Appeal Decision

Appeal Ref: APP/T2350/W/18/3206077

10 Knowsley Road, Wilpshire, BB1 9PX

- The appeal is made under section 78 of the Town and Country Planning Act 1990 against a refusal to grant planning permission.
 - The appeal is made by Mr & Mrs Coupland against the decision of Ribble Valley Borough Council.
 - The application Ref 3/2018/0263, dated 22 March 2018, was refused by notice dated 25 May 2018.
 - The development proposed is conversion and extensions to the former care home to create 5 dwellings.
-

EXISTING WEST ELEVATION

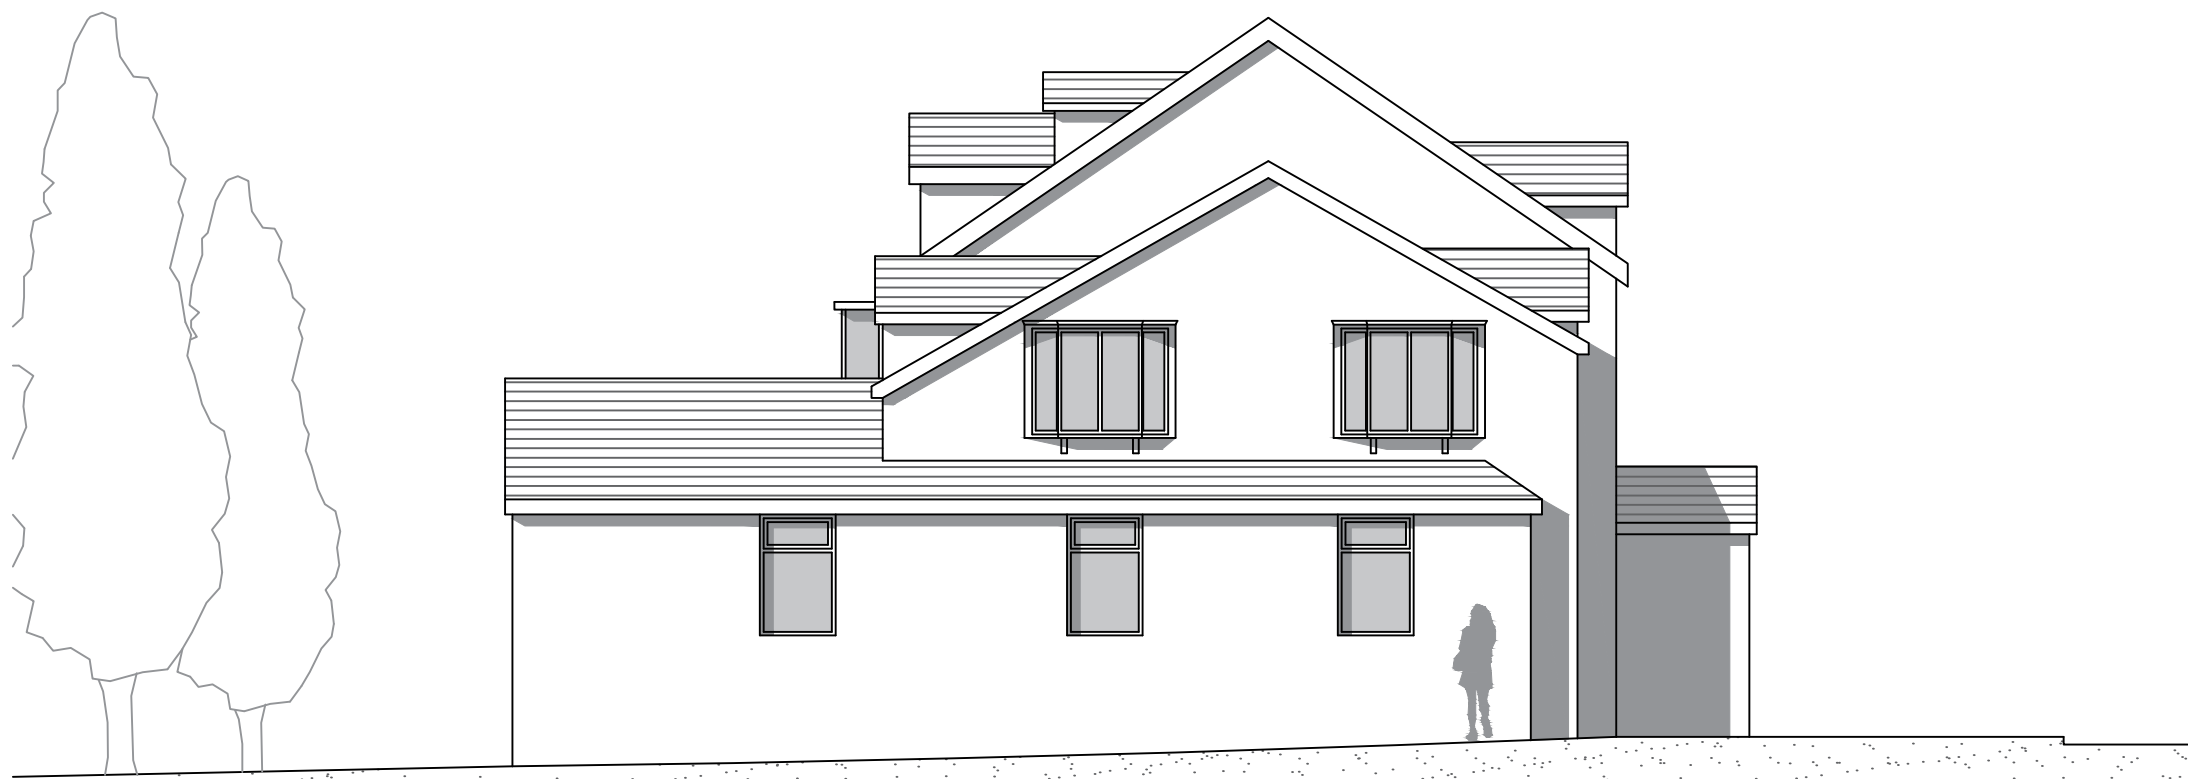
5. The proposed extensions would be subservient in appearance and incorporate features which reflect those of the original building and in this regard would be straightforward. However, in order for additional car parking to be provided, the proposal would result in the loss of the porch on the front of the original building, along with the stone wall, pavement and areas of soft landscaping. Whilst it appears that the porch was a later addition and notwithstanding the proposed incorporation of the date stone into the main façade, it is an attractive feature and its removal would have an adverse effect on the appearance of the building. Furthermore, the loss of landscaping and existing boundary features, to enable large areas of hard surfacing to be formed for car parking, would have an unacceptable urbanising effect which would cause material harm to the character and appearance of the area.

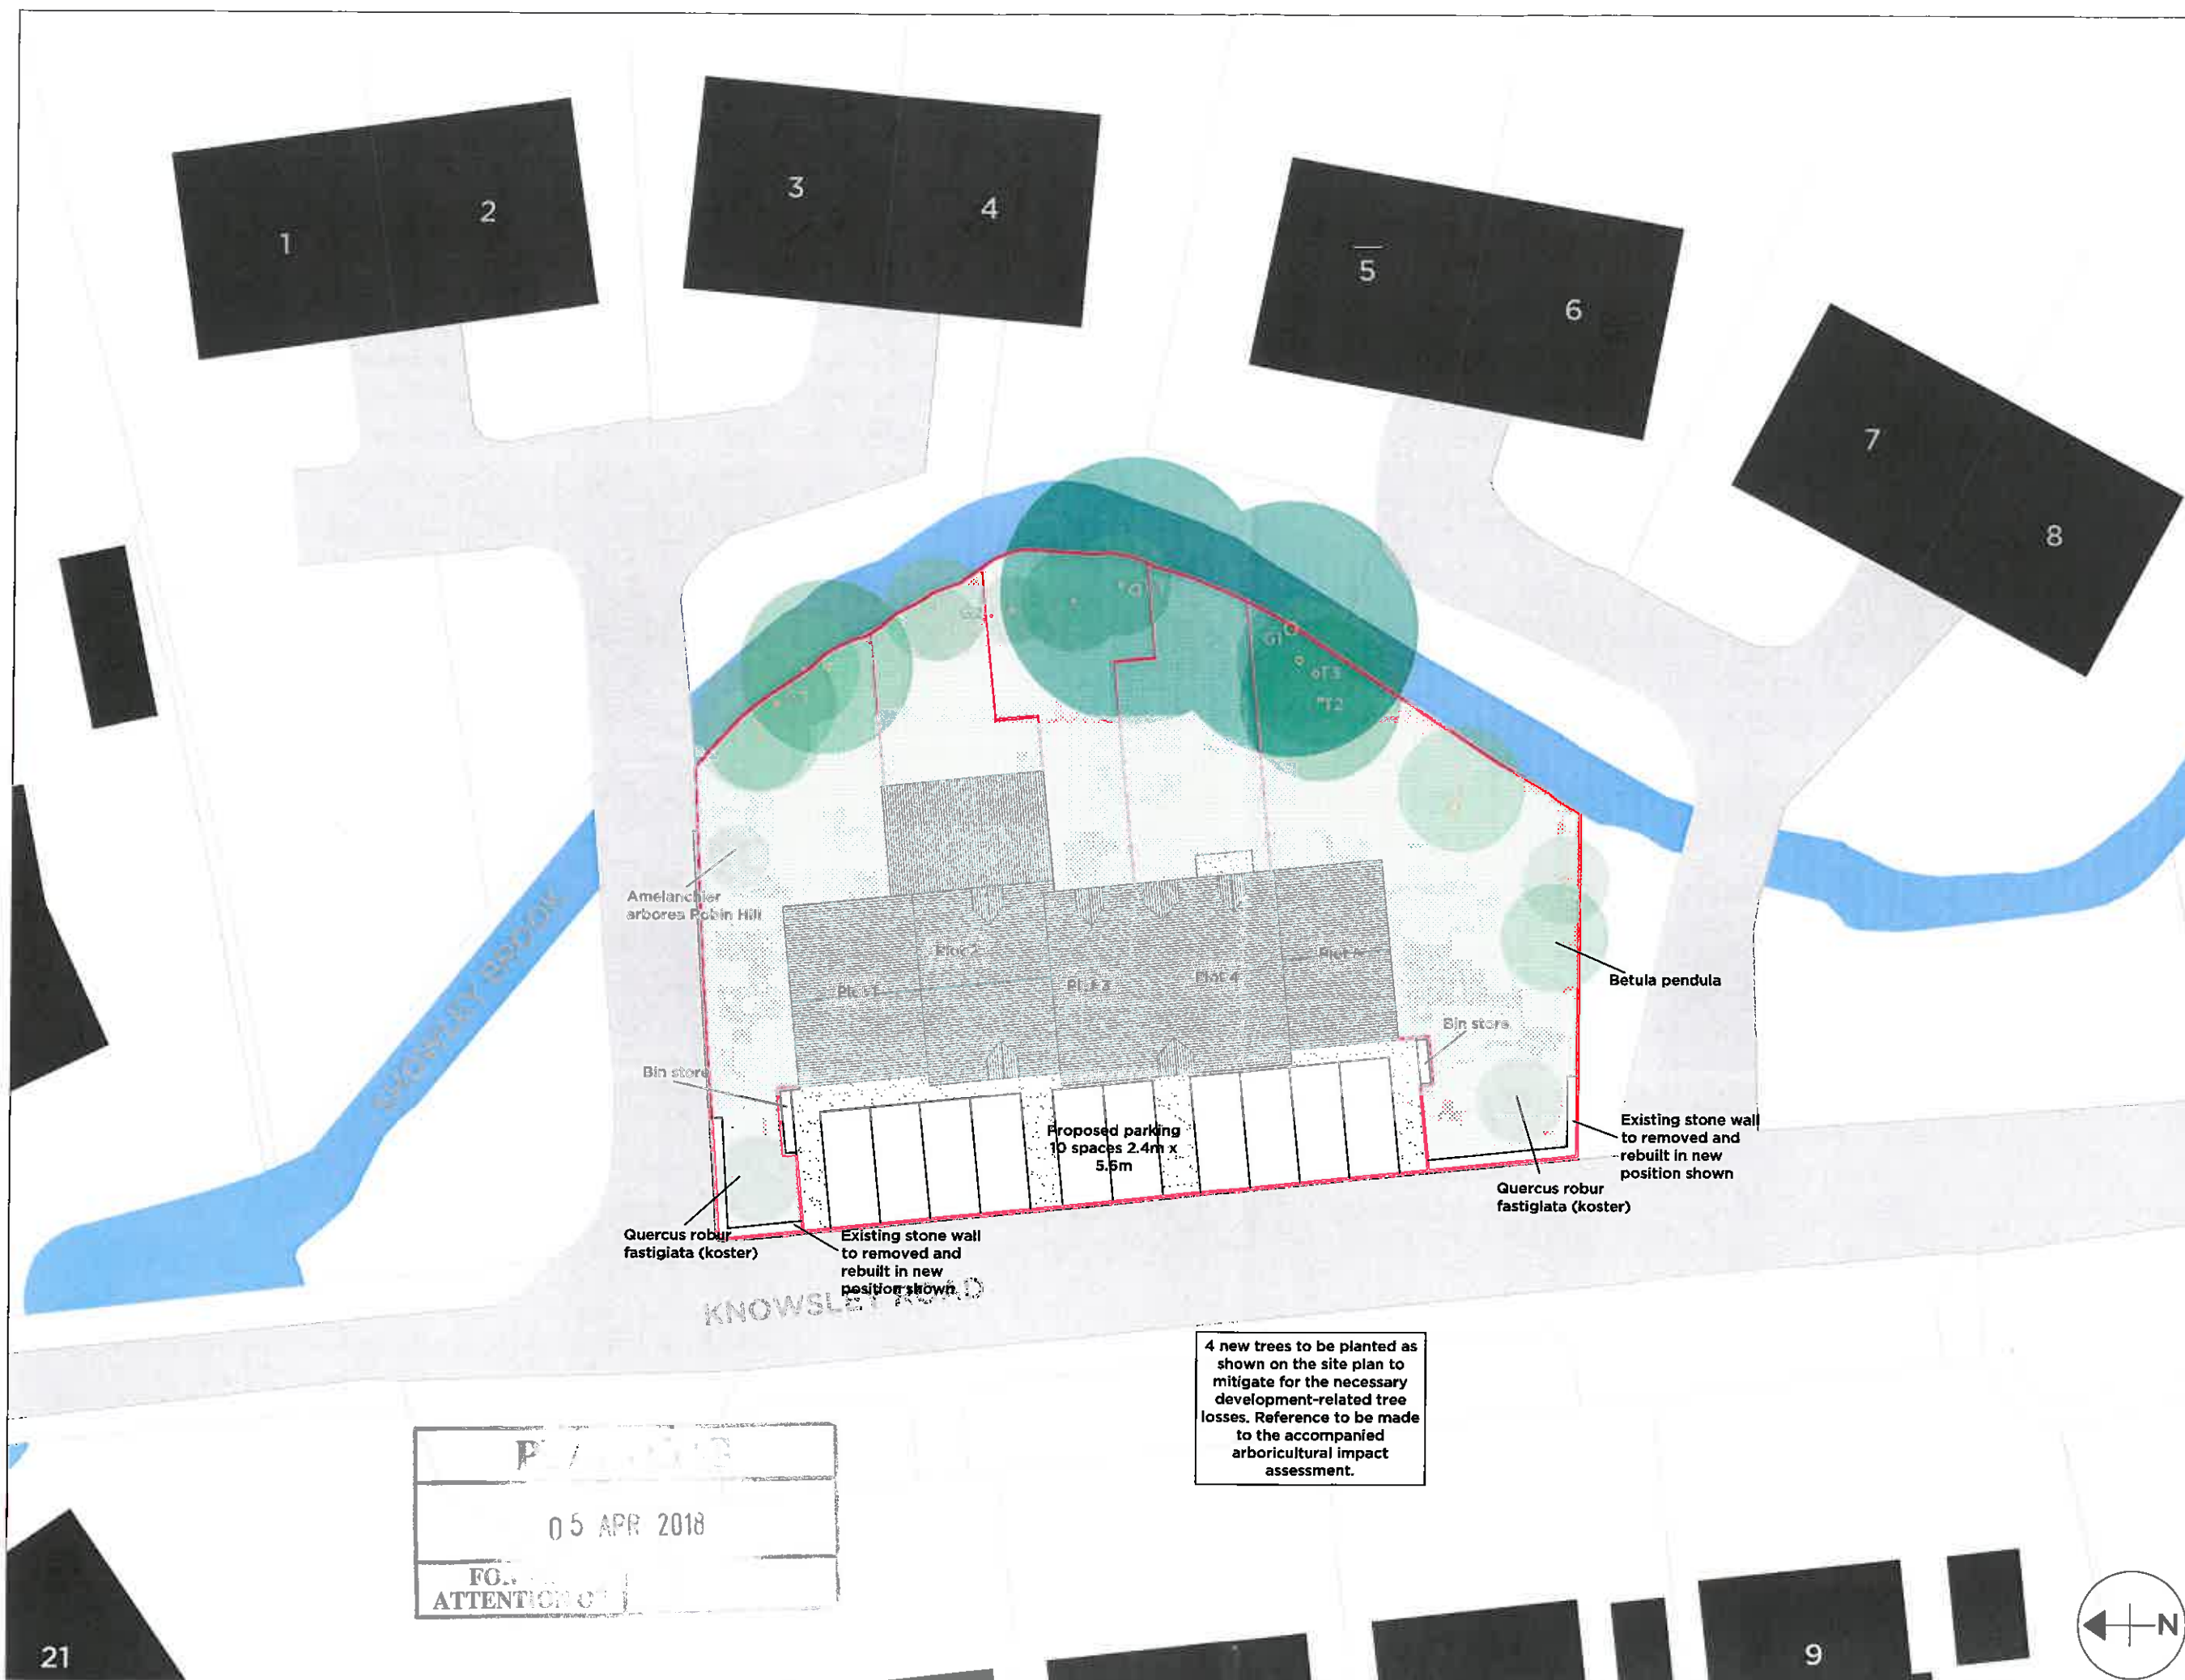
7. There appears to be dispute between the parties about whether the footpath to the front of the property forms part of the adopted highway. Even if I were to accept the appellants' position, the proposal would result in the whole of the frontage being given over to hard surfacing for car parking, which would result in vehicles being parked in very close proximity to the highway. I consider that this is likely to result in pedestrians having to step into the highway to unload vehicles.

8. Given the absence of turning space on the site, the proposal would result in vehicles either reversing out into the highway or manoeuvring in the highway to reverse onto the site. The constrained nature of the spaces would make reversing out into the highway more difficult because parked vehicles would restrict visibility. Reversing into spaces would present risks associated with performing manoeuvres in the highway. Both scenarios would pose a risk to the safety of users of the highway.

9. At my site visit I had regard to the visibility at both junctions of Clifton Grove with the highway. Visibility from the access north of the appeal site is restricted to the north by the bridge and at the south access, visibility is restricted to the south by an existing boundary. In parking vehicles up to the highway edge, the proposal would result in visibility being restricted in both directions for drivers of vehicles emerging from Clifton Grove to the detriment of highway safety.

10. Furthermore, in order to provide adequate parking spaces, it appears that there would be limited room for the placing of bins on collection days. This could lead to bins being placed on the parking area or in the highway and both scenarios would have the potential to interfere with the flow of traffic in the highway, posing a risk to the safety of users of the highway.
